Recommendation Report for Planning Permission for Works or Extension to a Dwelling

REF NO: R/164/18/HH

LOCATION: 3 Bushby Avenue
Rustington
BN16 2BZ

PROPOSAL: Two storey rear extension including rendering of brickwork chimney stack & deletion of dormer on west elevation (resubmission following R/67/17/HH)

REV. E

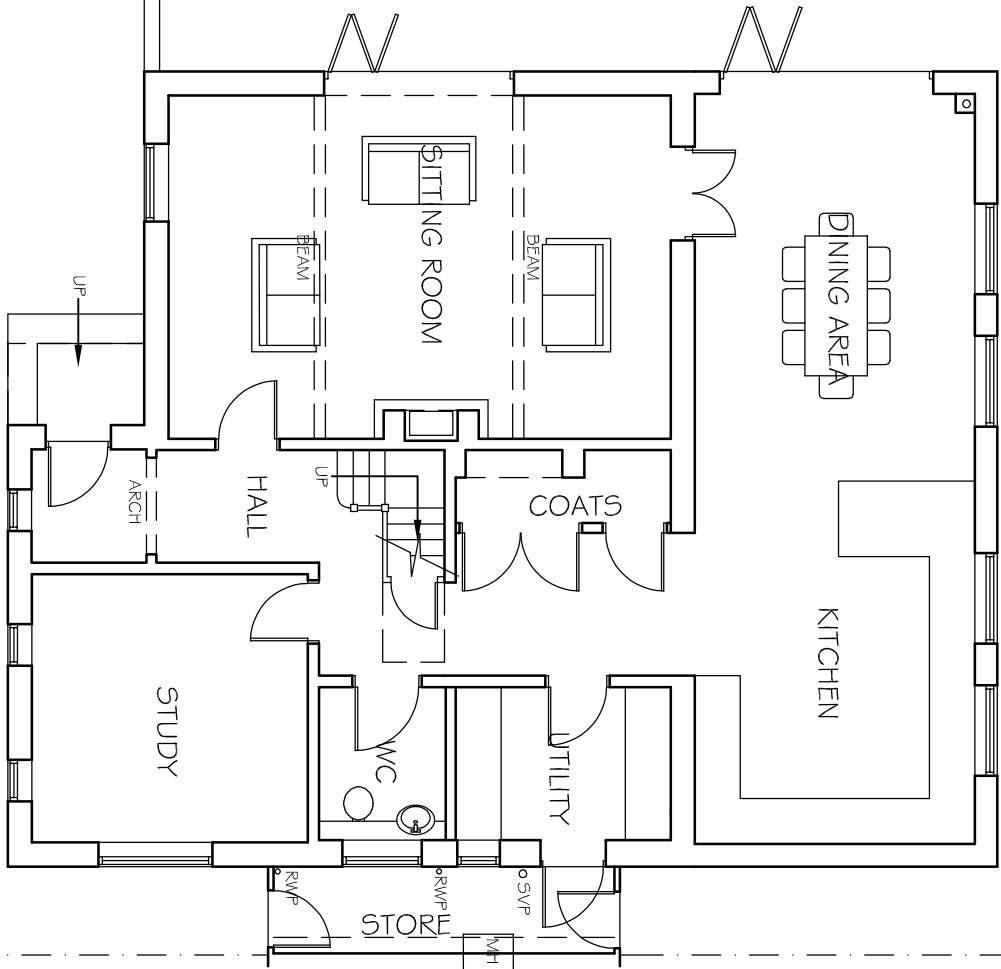
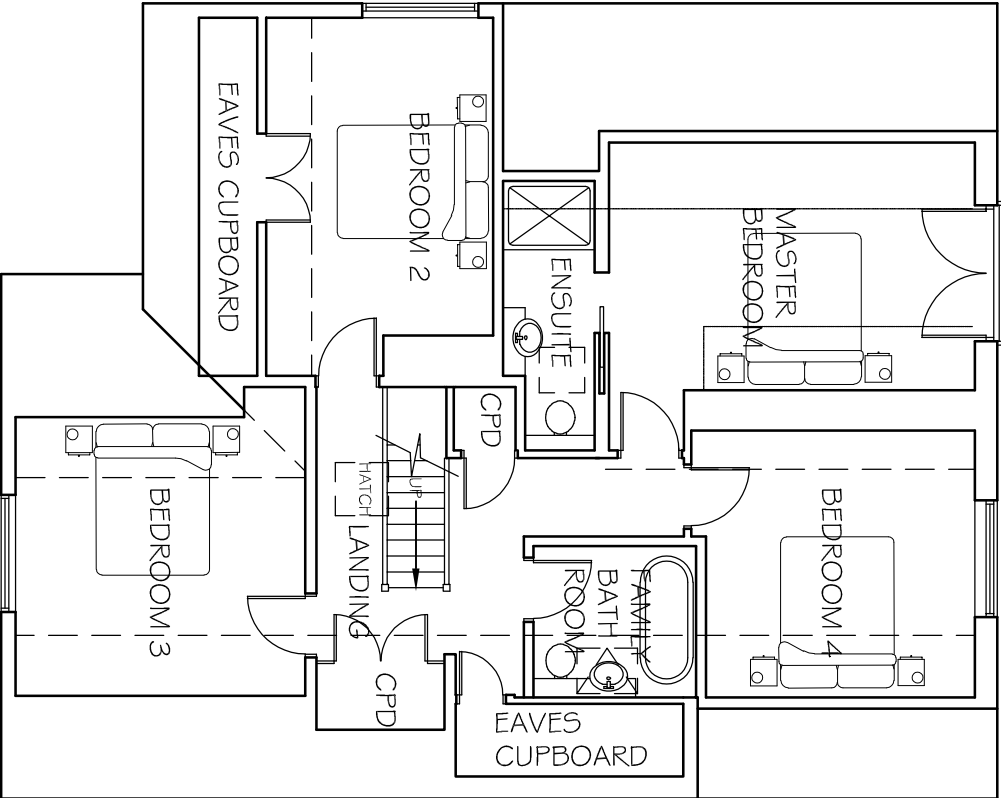
1 Letter of objection received
- The residents object to the patio door shown, believing that it causes loss of privacy to the occupants, and overlooks their rear garden.

Noted. The patio door referenced is approximately set at a distance of 17m from the nearest habitable window (set at an angle). This relationship is considered acceptable to protect the residential amenity of 9 Broadmark Lane.

PROPOSED ELEVATIONS

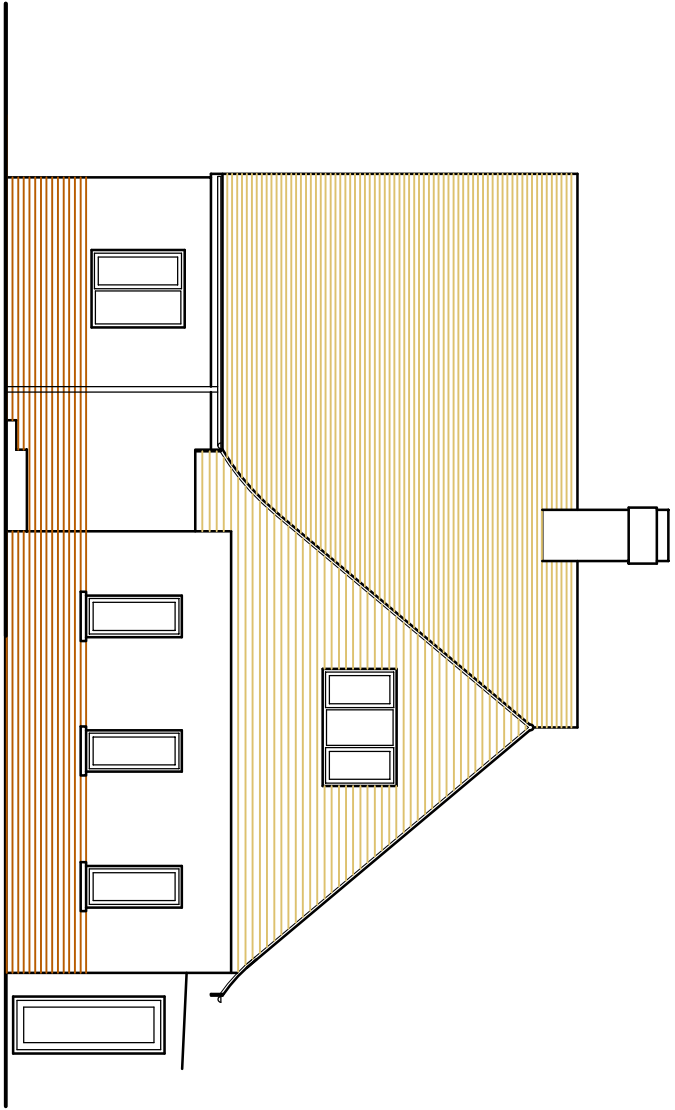
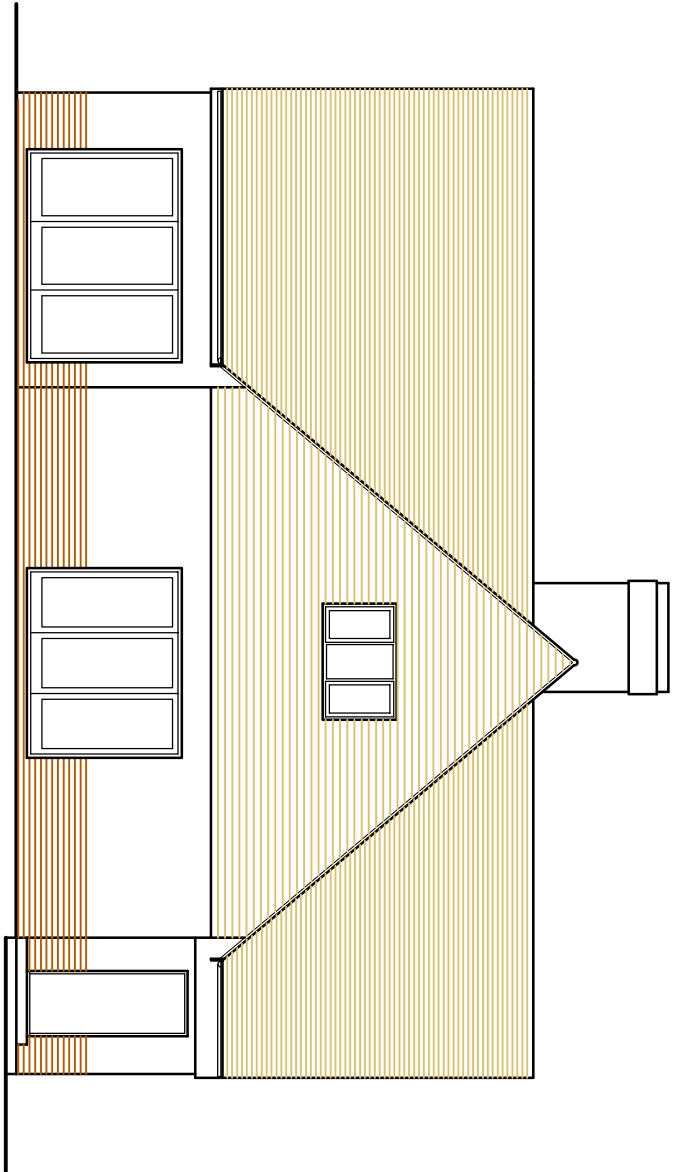
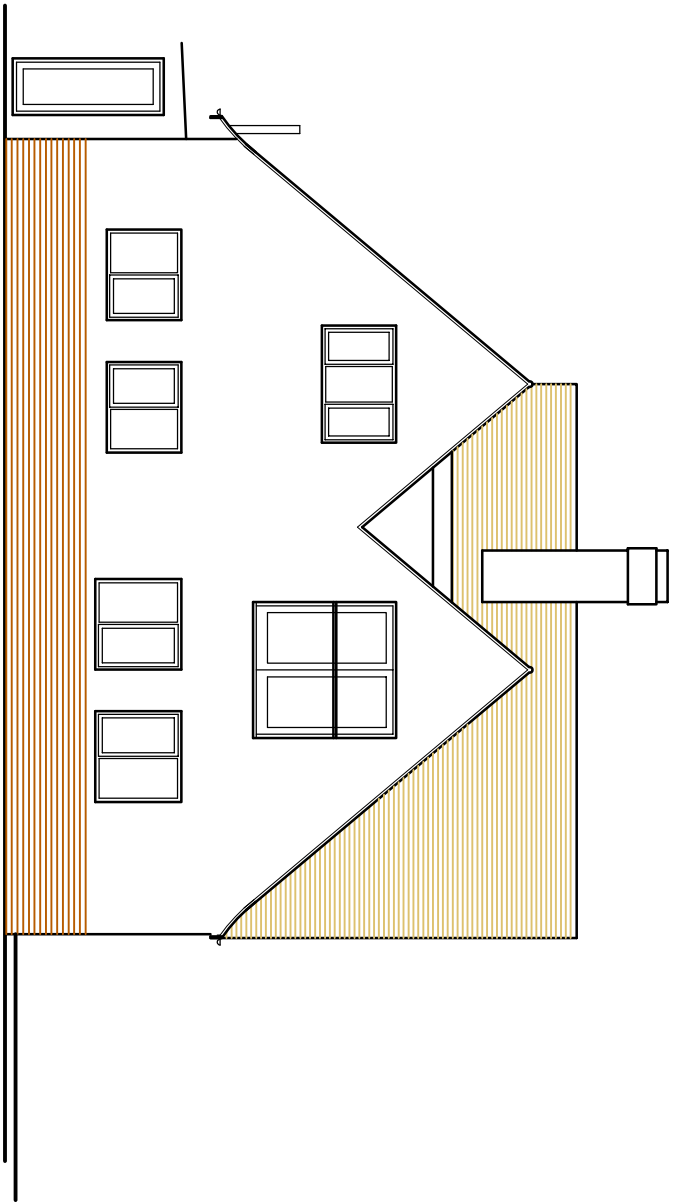
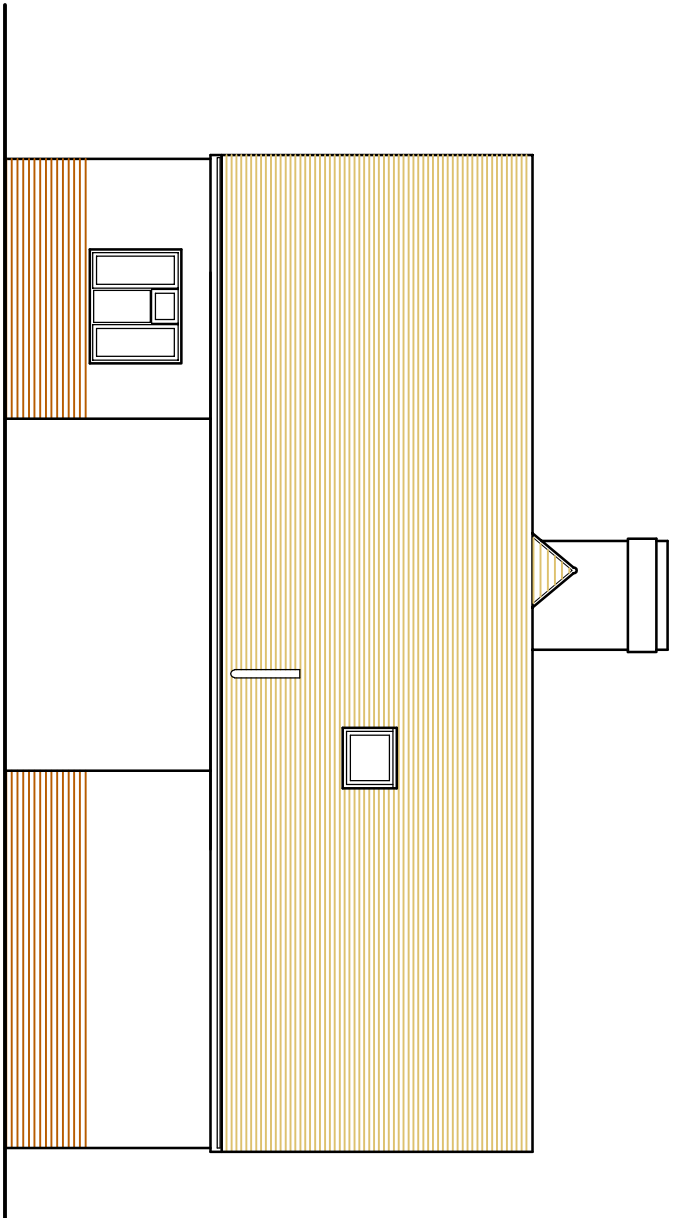
The tile hanging at the first floor level on the Western elevation is not considered to have a significantly detrimental impact on the host dwelling, as hung tile is not an uncommon material in the street scene. This is especially with reference to the fact that the adjacent dwelling to the East features this material.

The omission of the large dormer window on the first floor of the host dwelling is considered to be a reduction in the original scheme, and allows the proposal to appear more subservient within the plot, as it is smaller than originally. Additionally, the proposed changes to the Juliette balcony are also considered to be a reduction in the original scheme, as there are no longer side lights, and the width of the door itself has been reduced.

The majority of the changes to the scheme are considered to be reductions in the original scheme, with exception of the tile-hanging of the Western elevation. Resultantly, the proposed development is considered to be in accordance with D DM1 and D DM4 of the Arun Local Plan.
